From: Maria Tomalova <Maria.Tomalova@arun.gov.uk>
Sent: 24 February 2021 10:51
To: Planning.Responses <Planning.Responses@arun.gov.uk>
Subject: FW: BR/10/21/DOC, 12 Tennyson Road material submission

From: Maria Tomalova <Maria.Tomalova@arun.gov.uk>
Subject: BR/10/21/DOC, 12 Tennyson Road
Date: 22 February 2021 at 17:27:21 GMT
To: Adrian Burrows [REDACTED]

With regards to the above application, particularly condition 3 we will need the further information:

PROPOSED ELEVATIONS

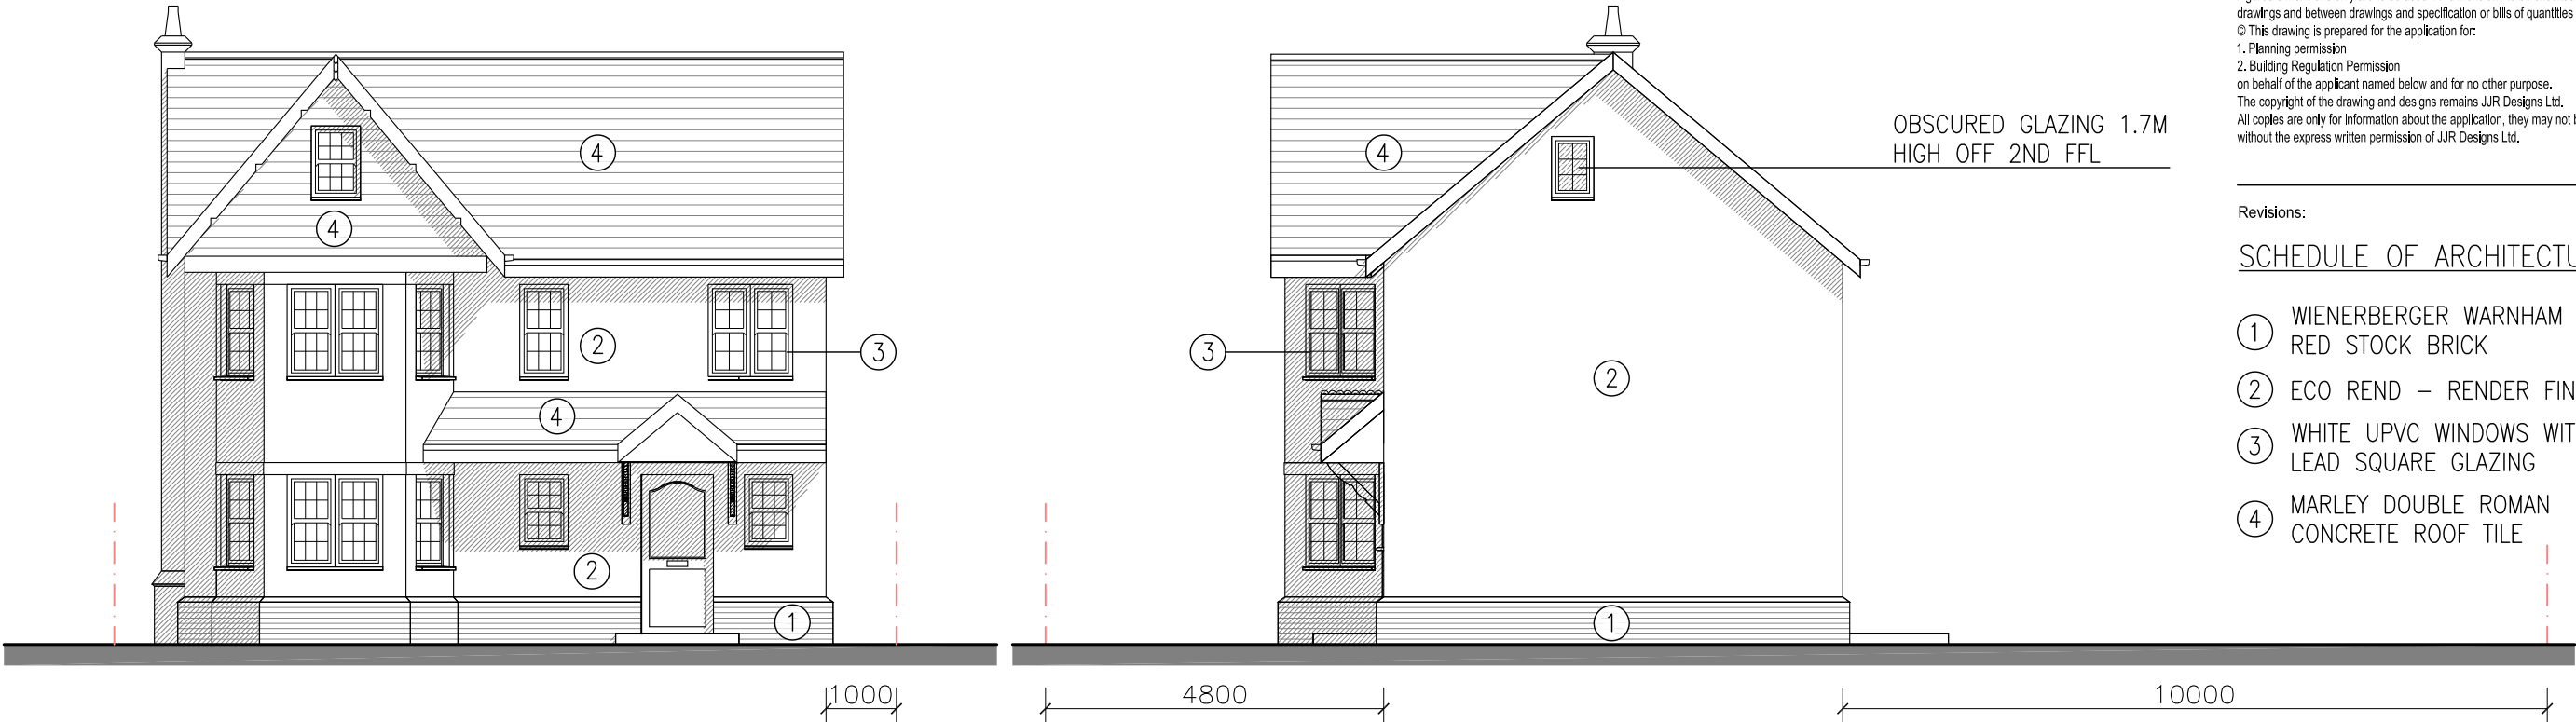
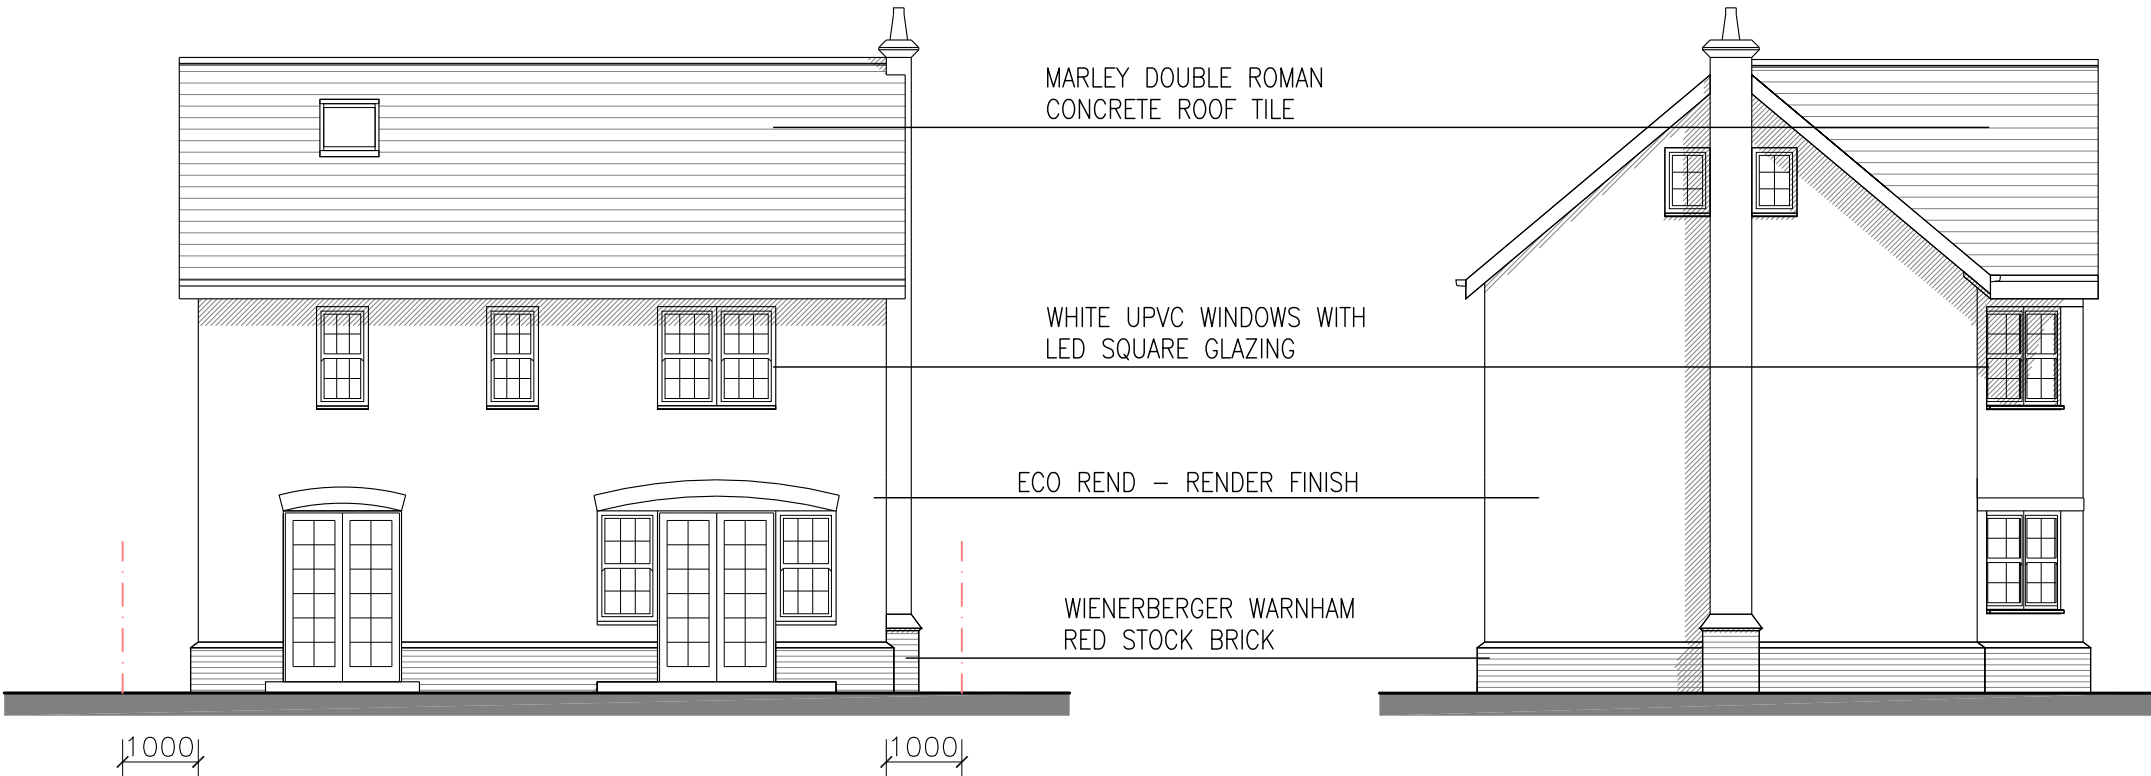
- the colour of render (it look s like white but there is not such an information within submitted documents)
- which colour of Double Roman (Tile Specification)? Drawings of Elevations show Marley Double Roman but no clue what colour since there is nothing like Marley in Tile Specification.

External walls eco rend render finish (cream) We were proposing a cream not white.

Roof tile Double Roman Concrete Roof Tile | Marley Ltd (Mosborough Red) If you click the link and click on the colour tiles the red one will show Mosborough red.
